Consultation Response from KC, Lead Local Flood Authority		
2020/90441 Pennine Service Station, Bradley Road, Bradley, Huddersfield, HD2 1QD		
Discharge conditons 3, 6, 7, 18 on previous permission 2019/92233 for erection of petrol filling station, including new shop building, canopy, jet-wash and below ground storage tanks		
Date Responded: 15 June 2020	Responding Officer: Aleksandra Tomczyk	Responding Ref: 1

Kirklees LLFA OBJECT to discharge of conditions 3 and 7 and require FURTHER INFORMATION to be provided on the design of surface water discharge system. Kirklees LLFA have no objection in principle, to discharge of condition 18. However, this condition cannot be recommended to be discharged before conditions 3 and 7 are fulfilled as well.

DRAWING NO
EWE/2497/01

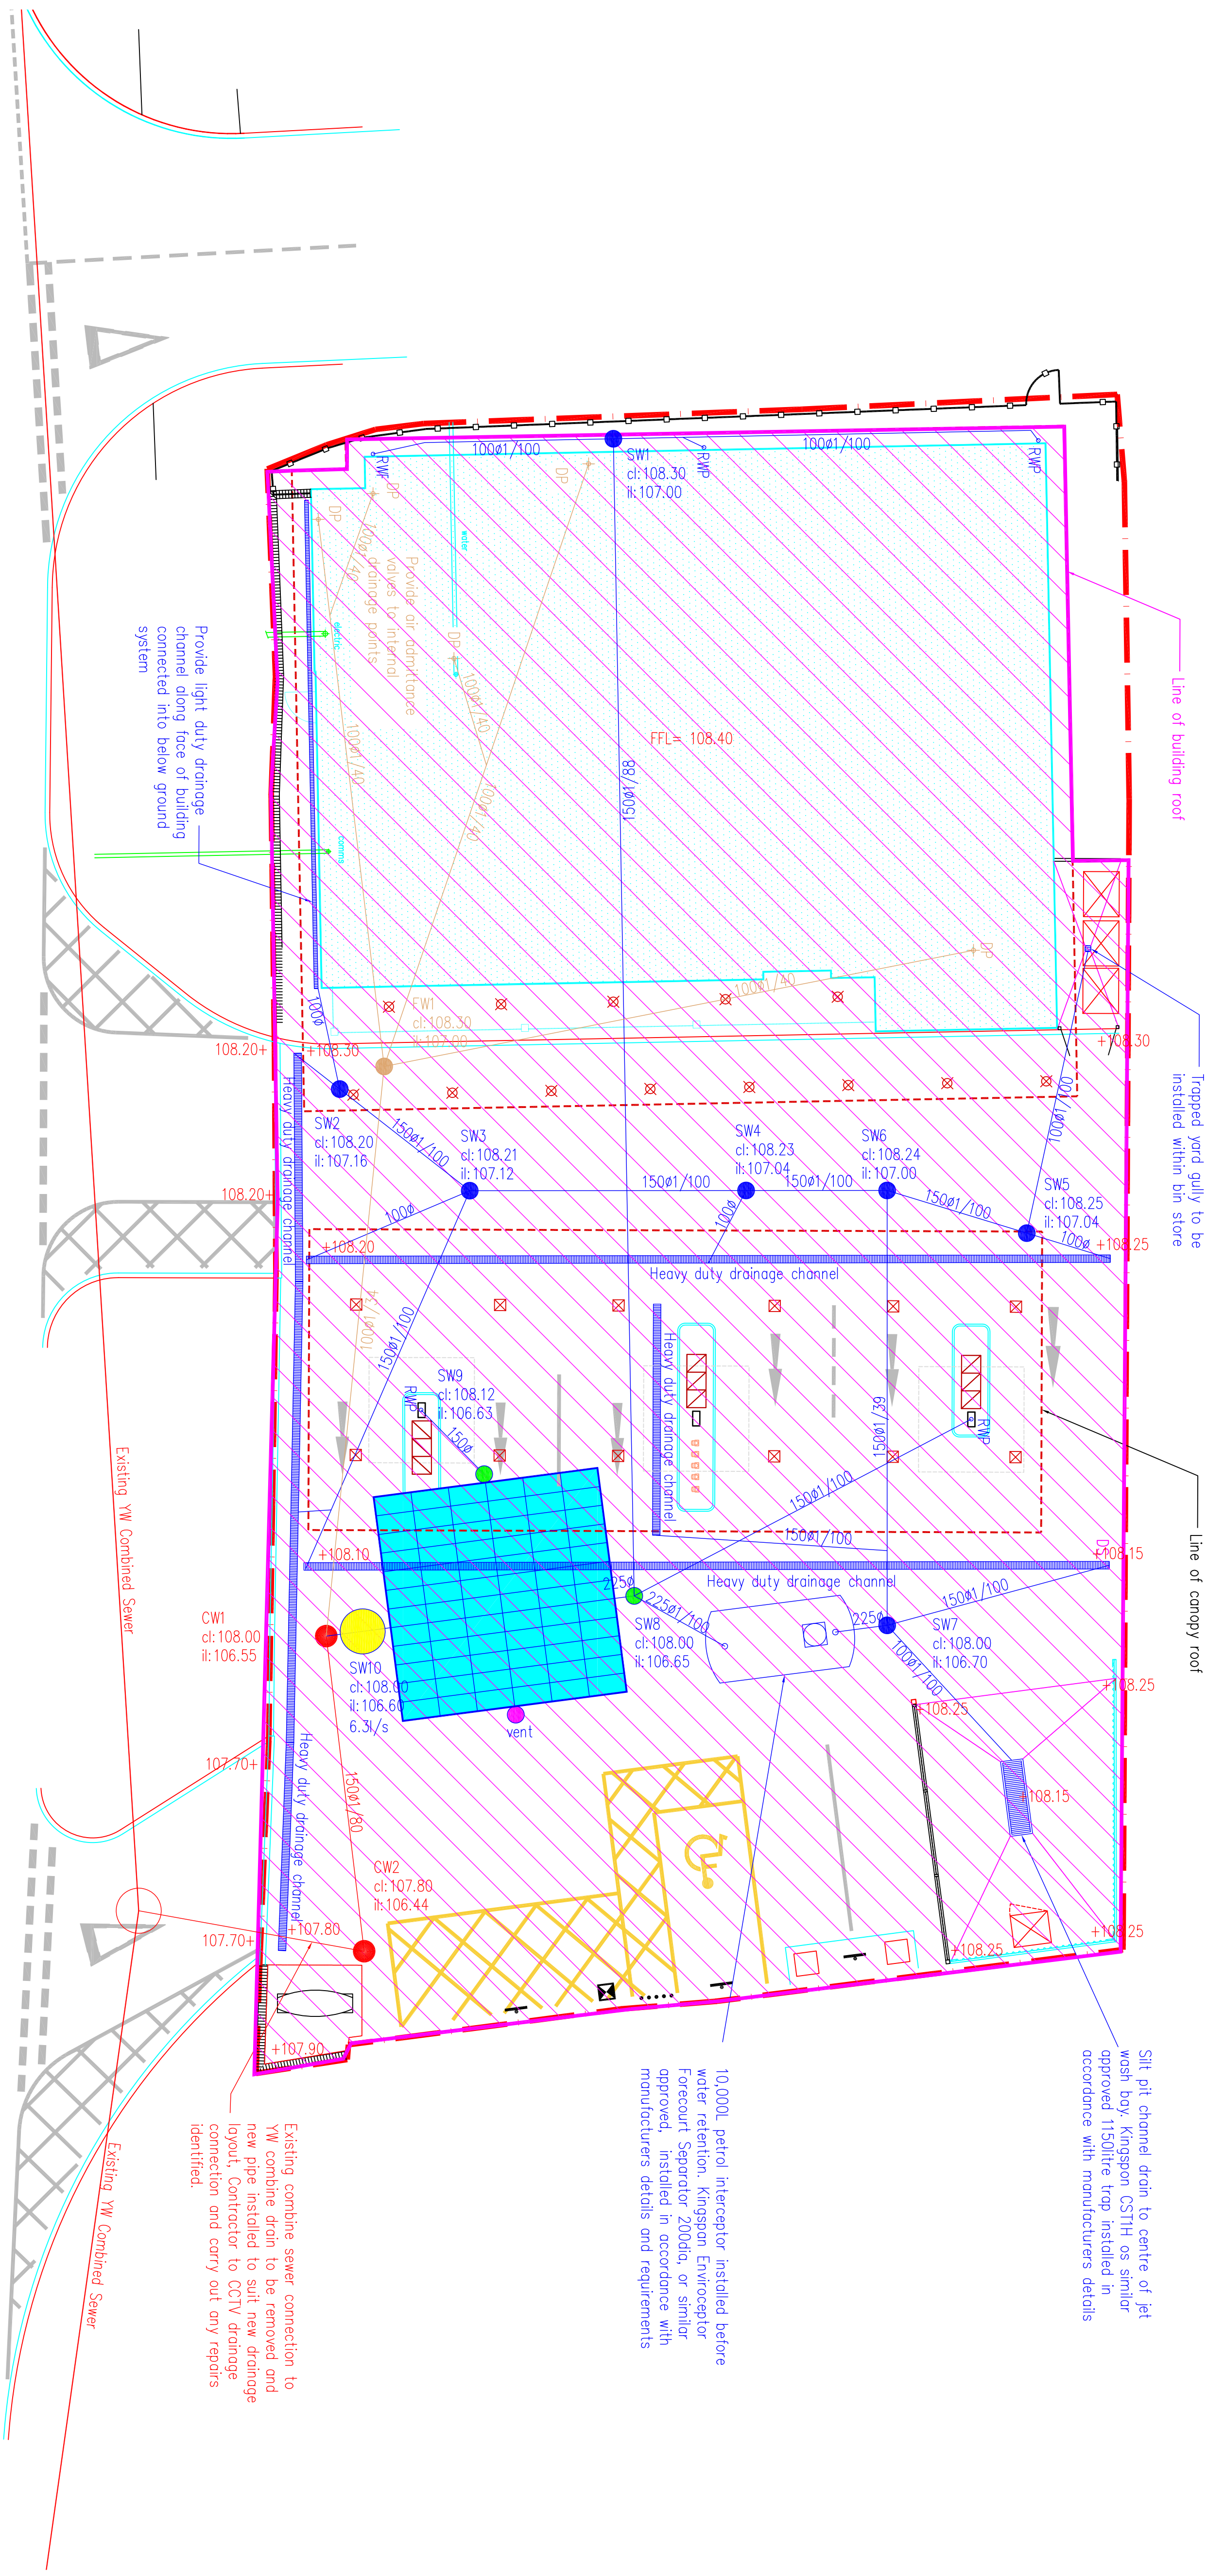
- The LLFA have previously requested the applicant provides details of the 'light duty' and 'heavy duty' channels proposed to be used on site. Some details of the heavy duty channel have been provided within the *Drainage Details* drawing, however, no lengths or details on the light duty channel have been shown. The applicant should provide these details, as requested in response reference 0.

- The LLFA have previously noted that water from the jet wash should not be connected to the surface water system. Water from cleaning areas will be silt laden and also contain cleaning contamination, this could result in siltation or contamination of water. The connection has now been changed and the jet wash water is proposed to be discharged as foul. The LLFA highlight that the applicant should consult with Yorkshire Water as the jet wash may require a flow control or an attenuation feature for balancing.

The applicant should review this proposal and provide updated information.
